Application Ref:	3/2026/0403	 Ribble Valley Borough Council www.ribblevalley.gov.uk	
Date Inspected:	N/A		
Officer:	BT		
DELEGATED ITEM FILE REPORT:		Decision	REFUSAL

Development Description:	Prior notification for proposed agricultural building under Part 6 Class A of the GDPO.
Site Address/Location:	Land to the East of Slaidburn Road, Waddington, BB7 3AA.

PROPOSED ELEVATIONS  
 (Sheet 1 of 2)

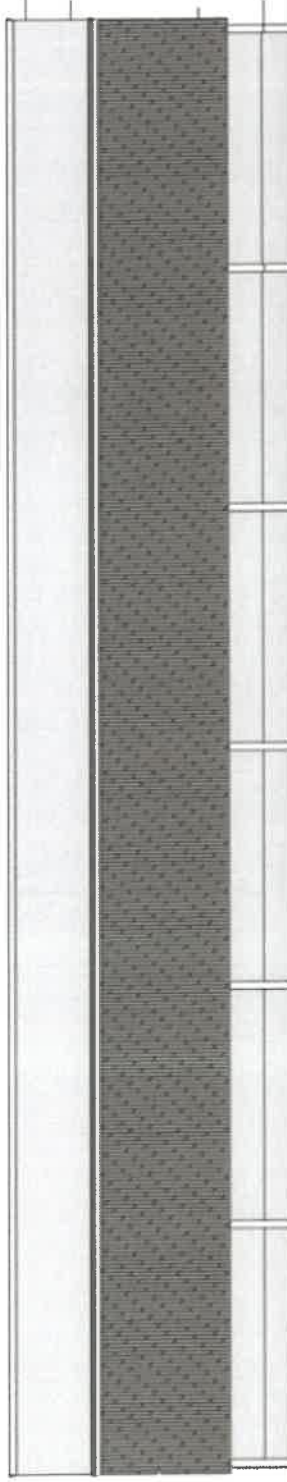
The highest part of the proposed building would be 4.2 metres, within the above threshold limit

The proposed building would consist of a steel portal frame, concrete panels, Yorkshire boarding and profiled green roofing sheets, all of which are materials commonly used in the construction of modern agricultural buildings. Notwithstanding this, and as conveyed above, the proposed building would be a sizeable structure with regards to its footprint at 167m² and would be visible in the public realm and as such is not considered to be appropriate with respect to its design in the context of the application site's open and visually sensitive setting.

As such Prior Approval is refused with respect to the design of the proposed development.
